Stage I Project Application, Wolli Creek Retail Development

78 – 96 Arncliffe Street and 31 - 45 Princes Highway
Wolli Creek

Response to Submissions

April 2010

01 Signage Type 1, on Plant Area
 Scale 1:50

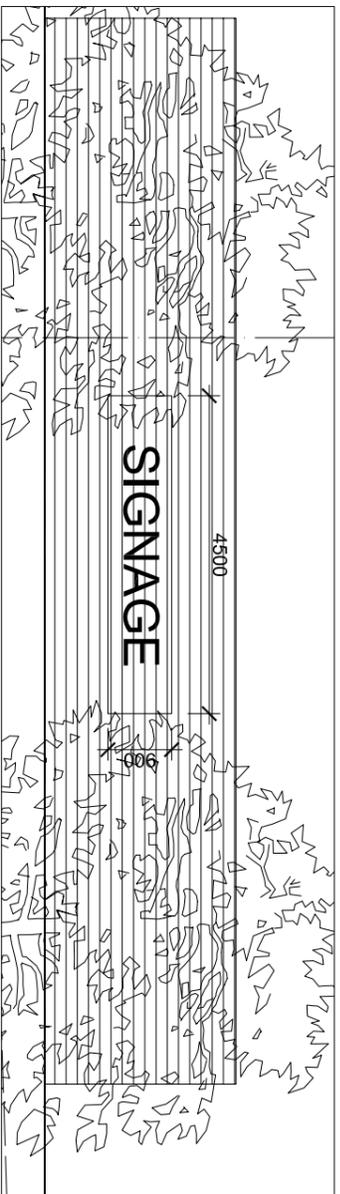
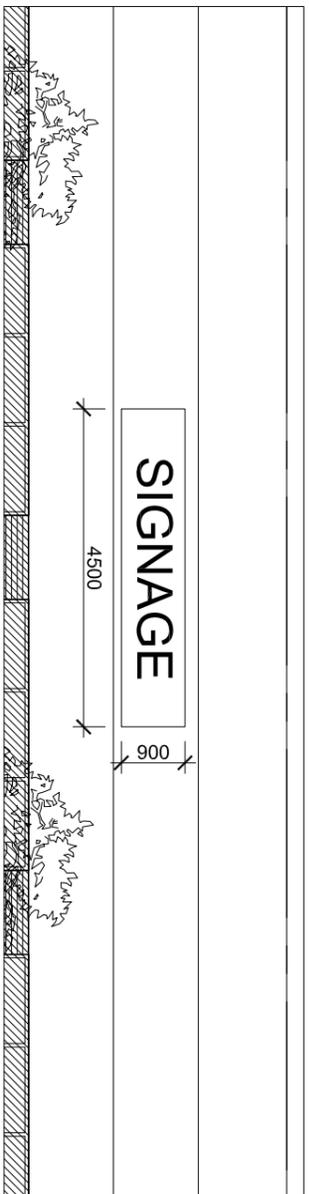
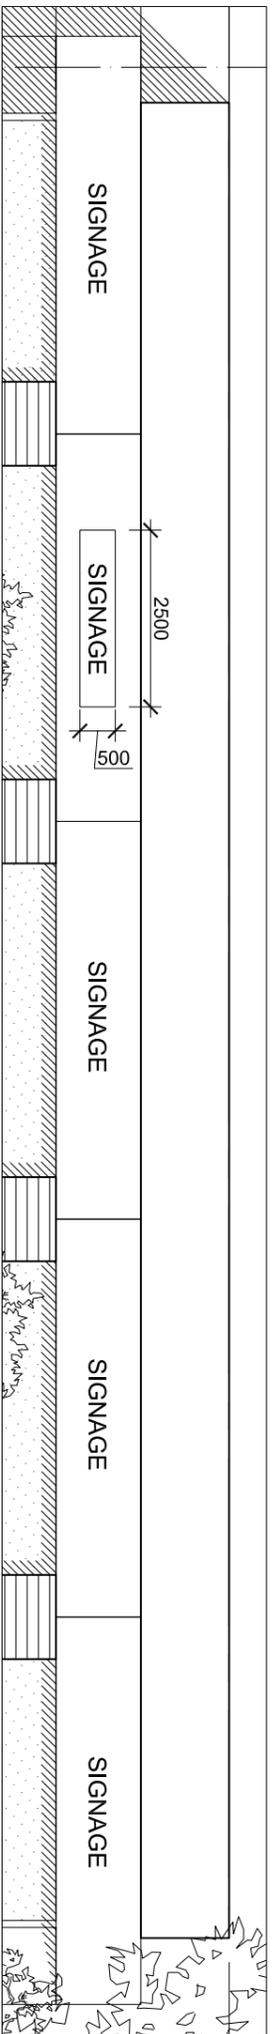
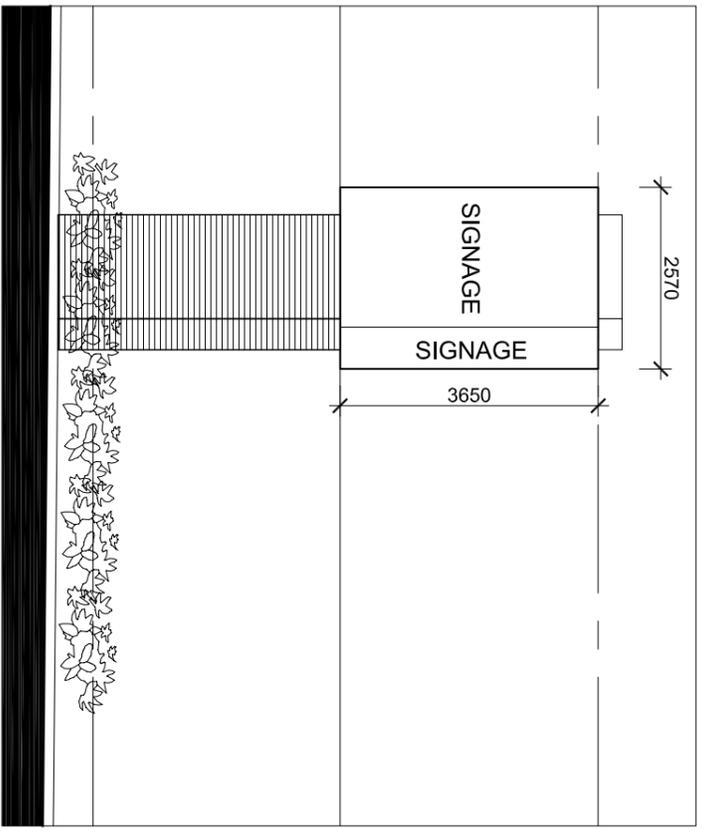
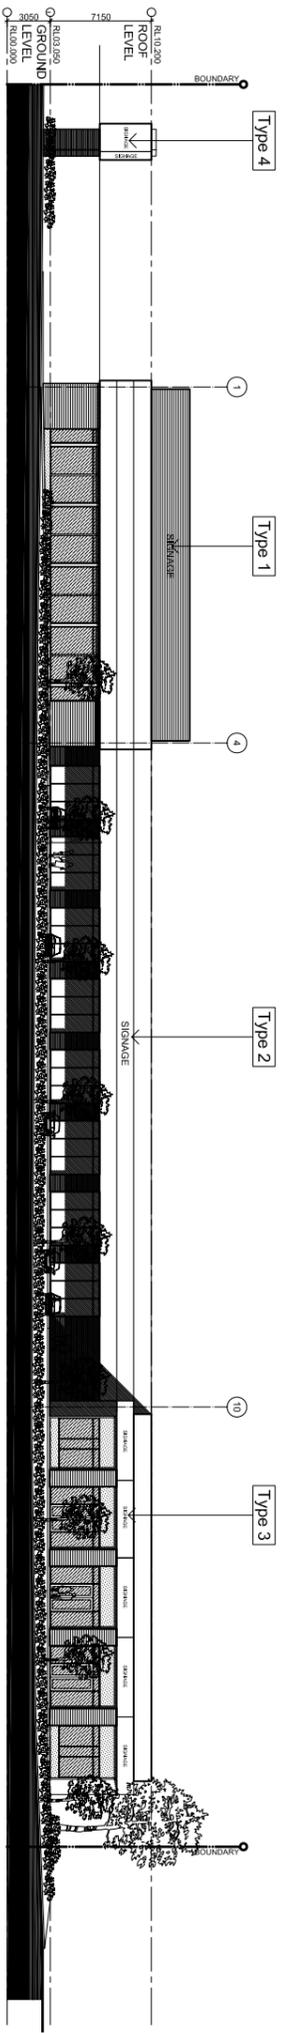
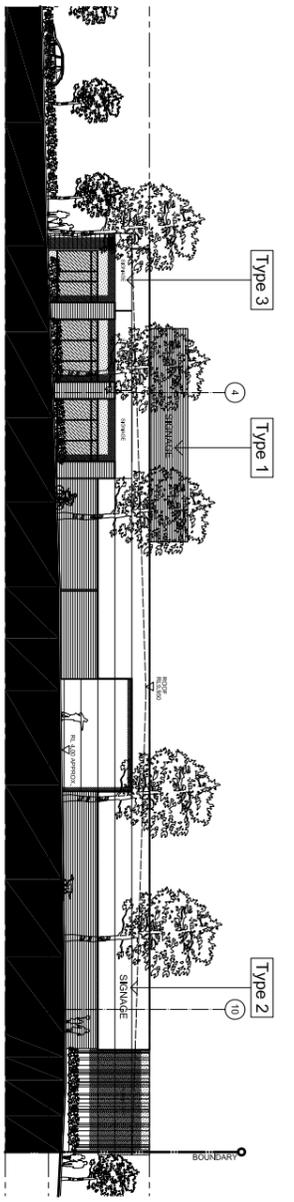
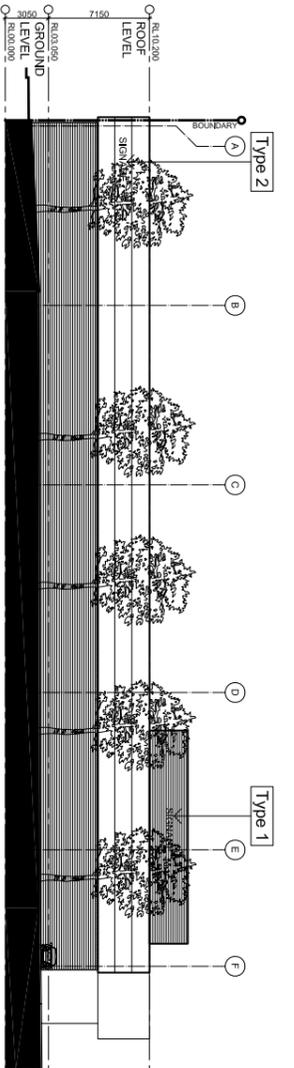
Item	Issue	Submission	Response
9	Signage	The proposed Signage strategy is not supported mainly in that it lacks details (including contents) to enable a proper assessment under SEPP 64, RLEP 2000 and DCP 29. Concerns are raised regarding Signage Type 1 and Type 4. It is recommended that a separate application be submitted for the proposed signage. Alternatively full details and photomontages shall be provided prior to determination of the application.	A separate detailed signage development application will be lodged with Council.
10	Parking and Access	Specific Issues Listed Below	
10a		Council's Driveway Policy requires driveways to be constructed square to the kerb. The proposal does not comply with this requirement.	The carpark access referred to is located on the Princes Highway (not a Council road). The RTA has a preference for high use accesses on arterial roads to be slightly angled to facilitate ingress movements. The proposal is only very slightly angled and in reality reflects the normal travel path on a wide access driveway.
